From: Laura Gibbons <Laura.Gibbons@arun.gov.uk>
Sent: 10 August 2021 14:05
To: Planning.Responses <Planning.Responses@arun.gov.uk>
Cc: Simon Davis <Simon.Davis@arun.gov.uk>
Subject: RE: Planning Re-Consultation on: BN/98/21/DOC

Engineers Comments Regarding Condition 10

Application No: BN/98/21/DOC

Site Address: Land North of 1 Northfields Cottages Fontwell Avenue Eastergate PO20 3RX
Grid Reference: 494714 106230
Category: Discharge of Condi
Description of Works: Approval of details reserved by condition imposed under BN/50/20/PL relating to conditions

NOTES:

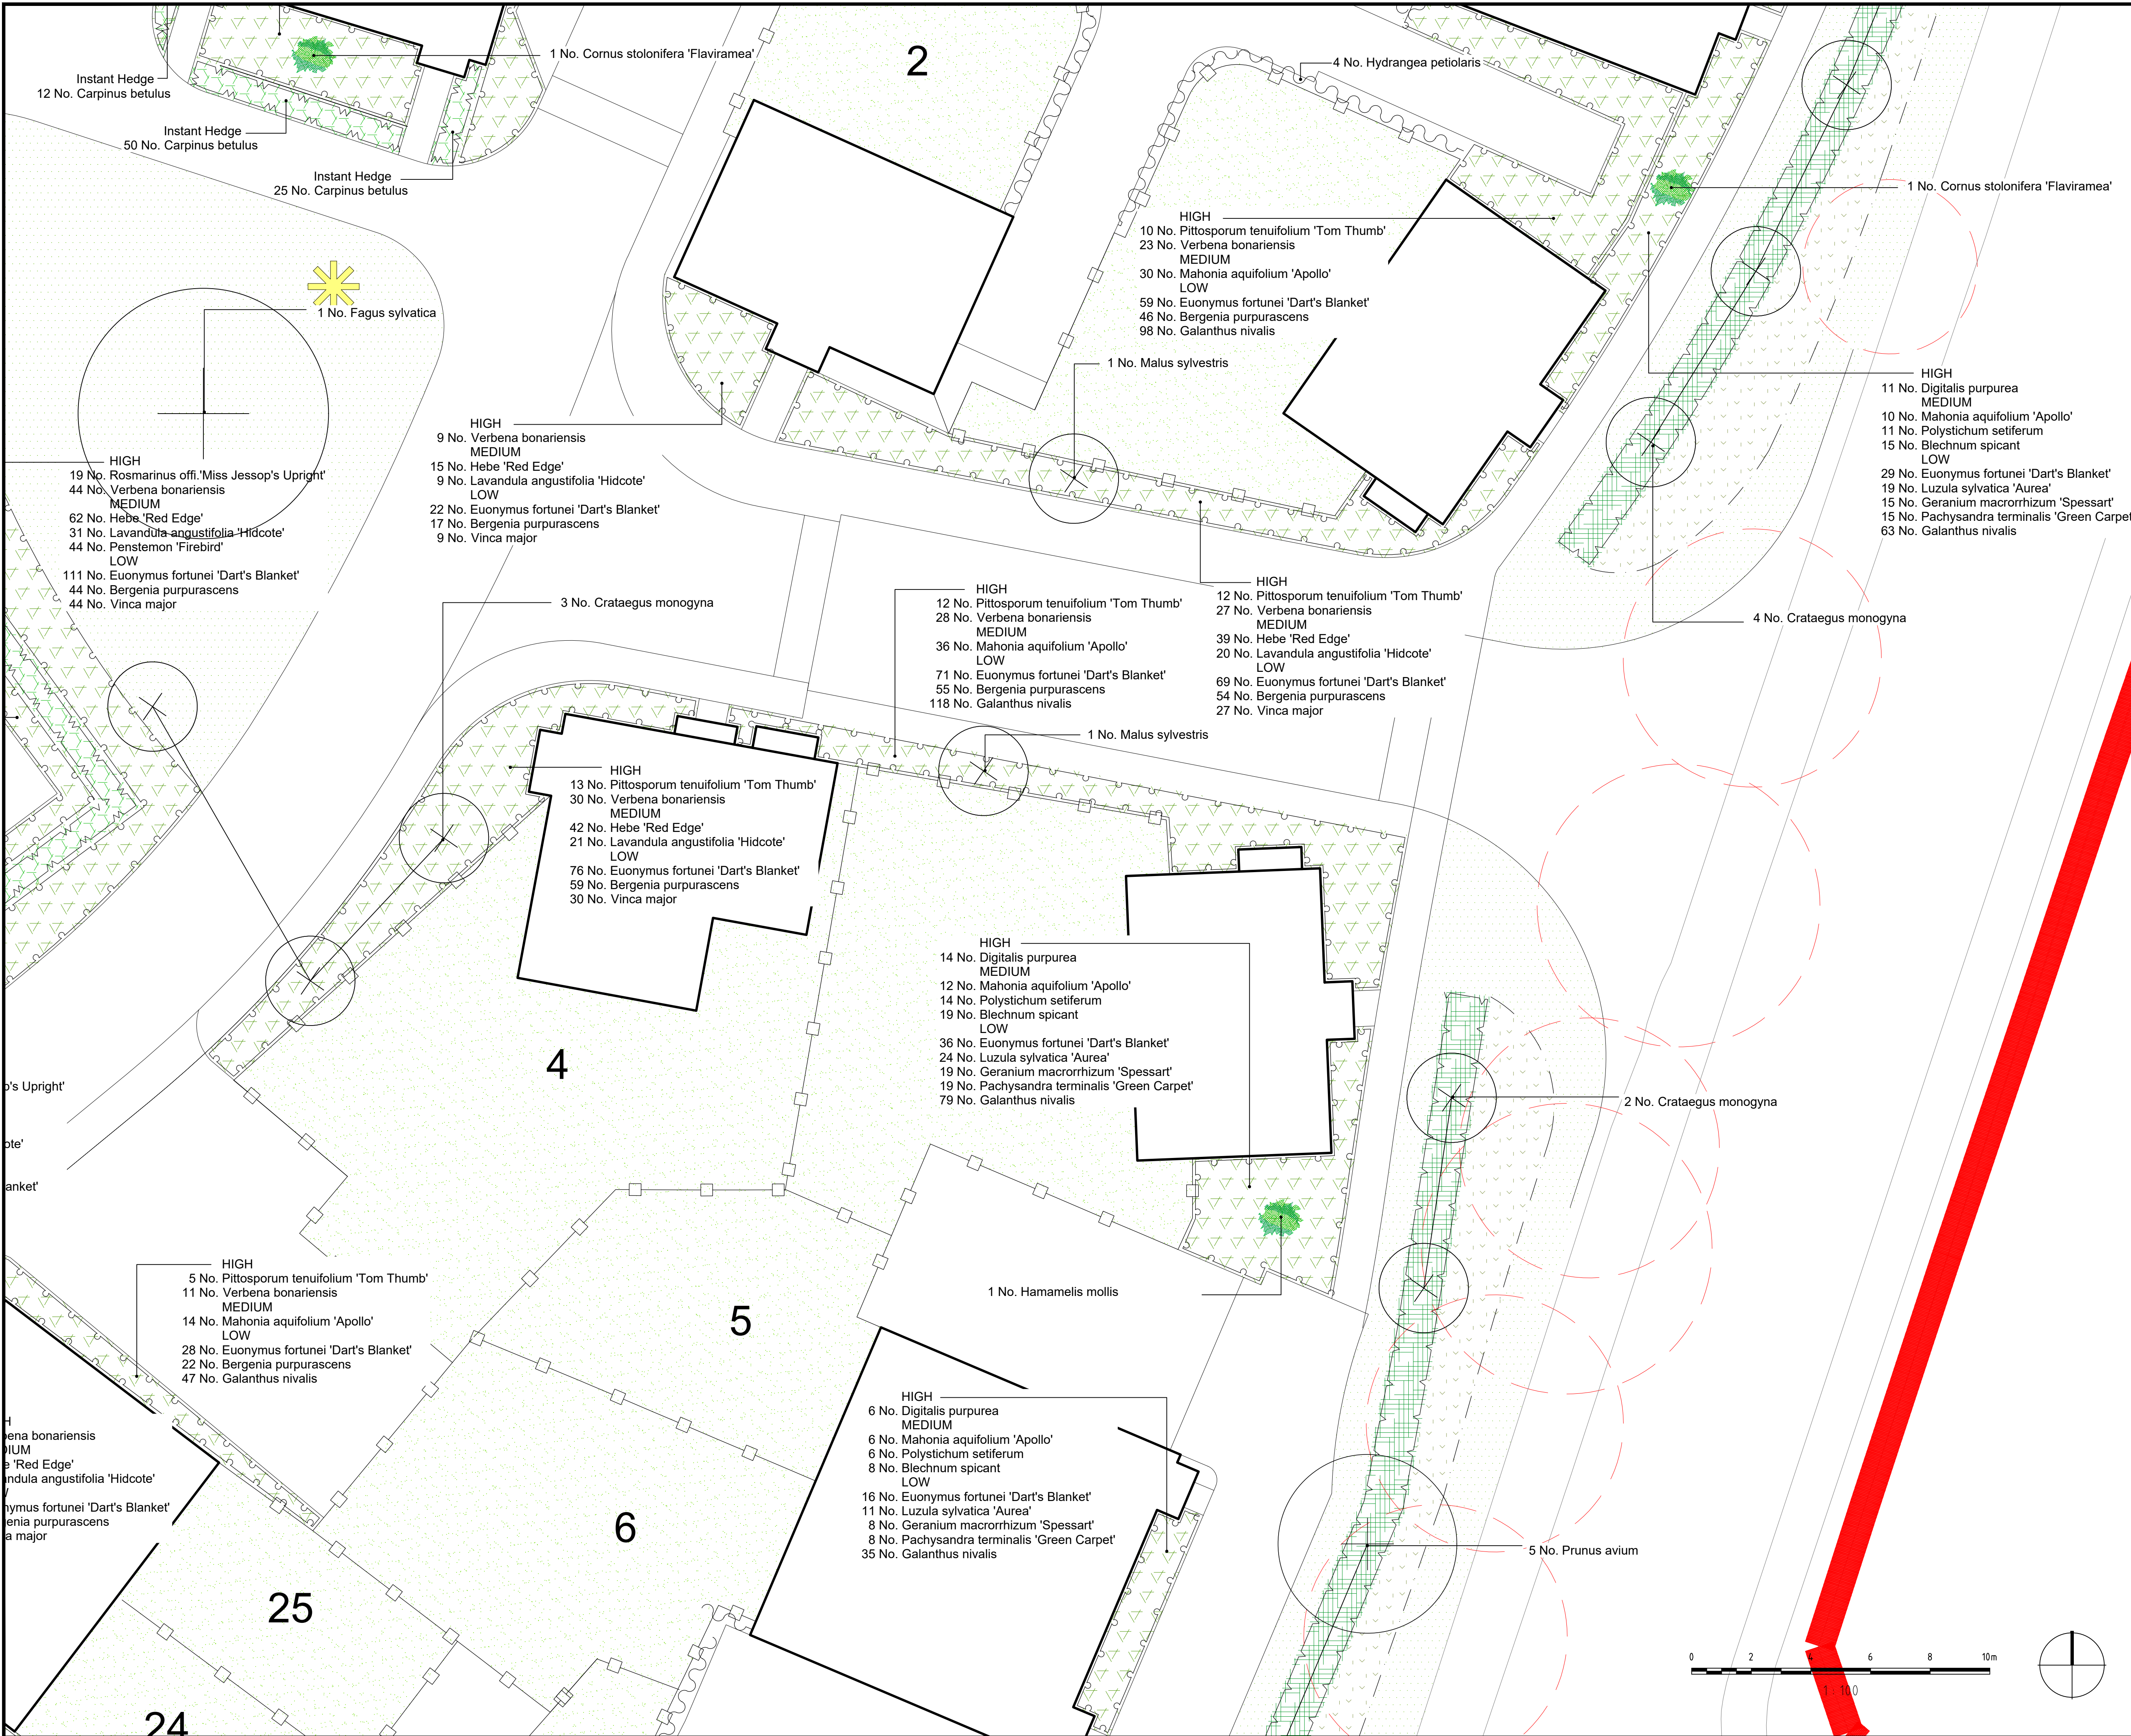
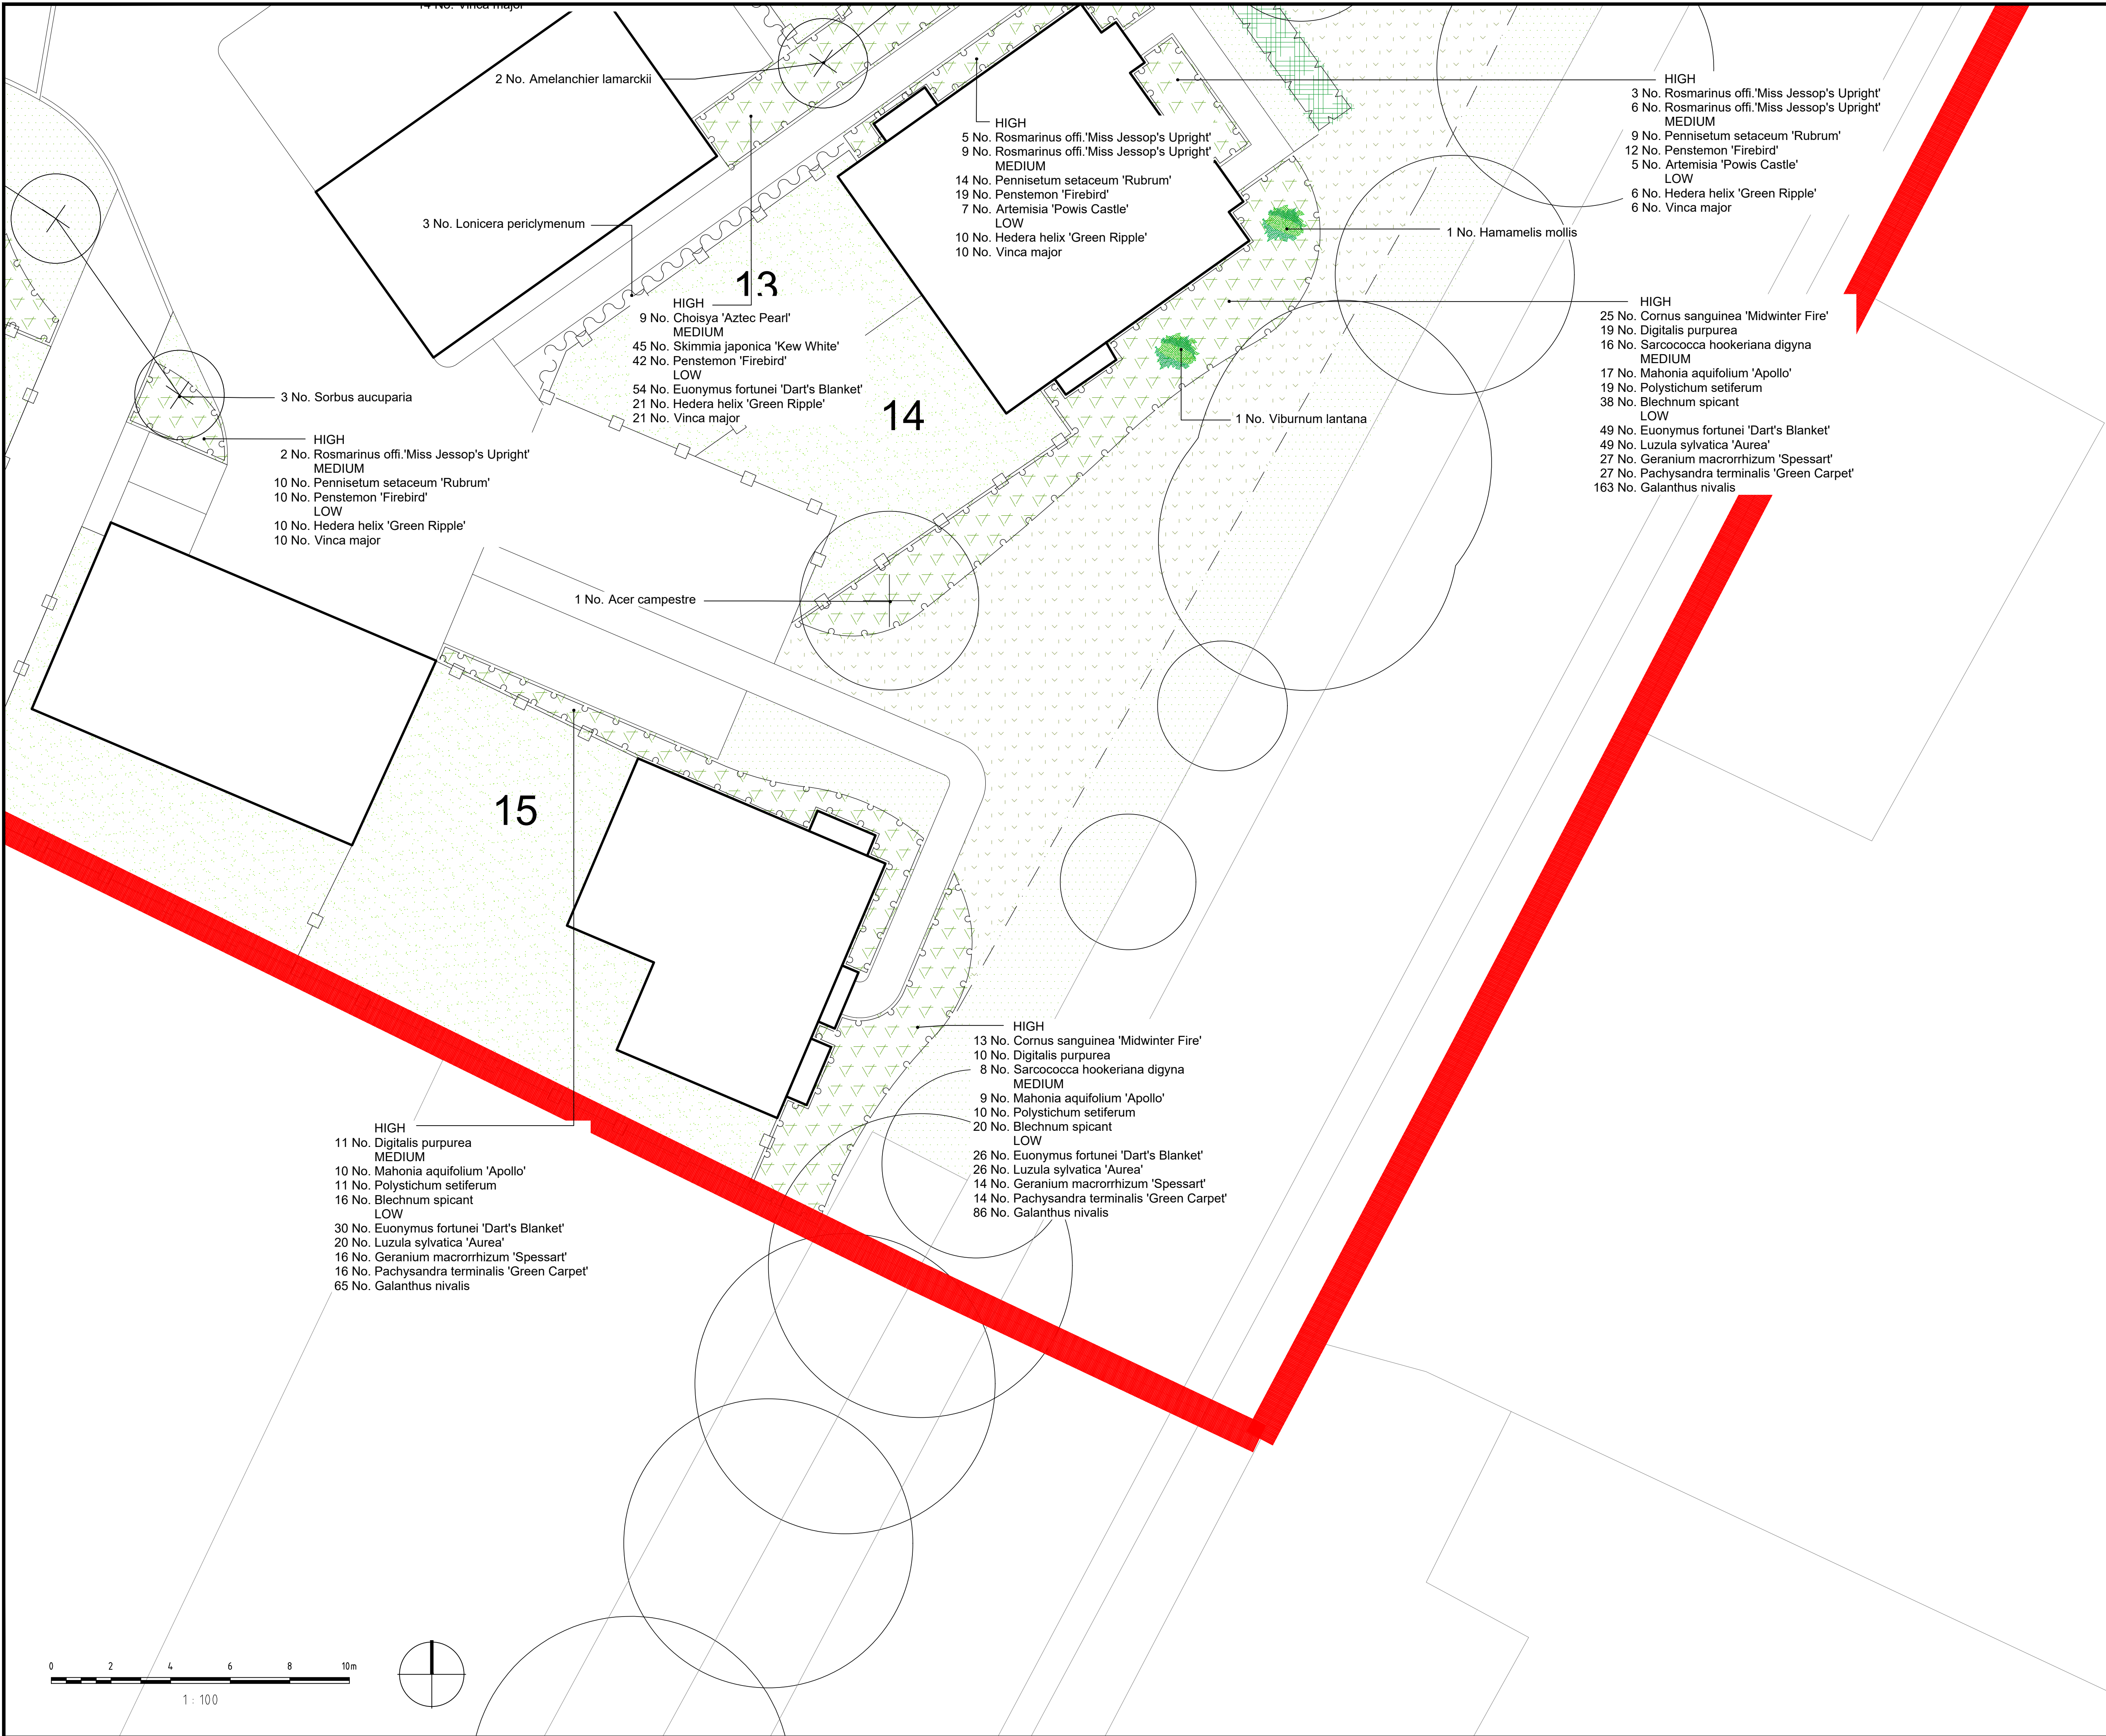
- The drainage layout needs to be more detailed, i.e. include details of the pipe networks e.g. pipe diameters, falls, manhole cover and invert levels, catchpits, etc.
- There is significant conflict between the proposed landscaping plans and the proposed drainage. This must be resolved so that trees are not proposed over pipes or crates.
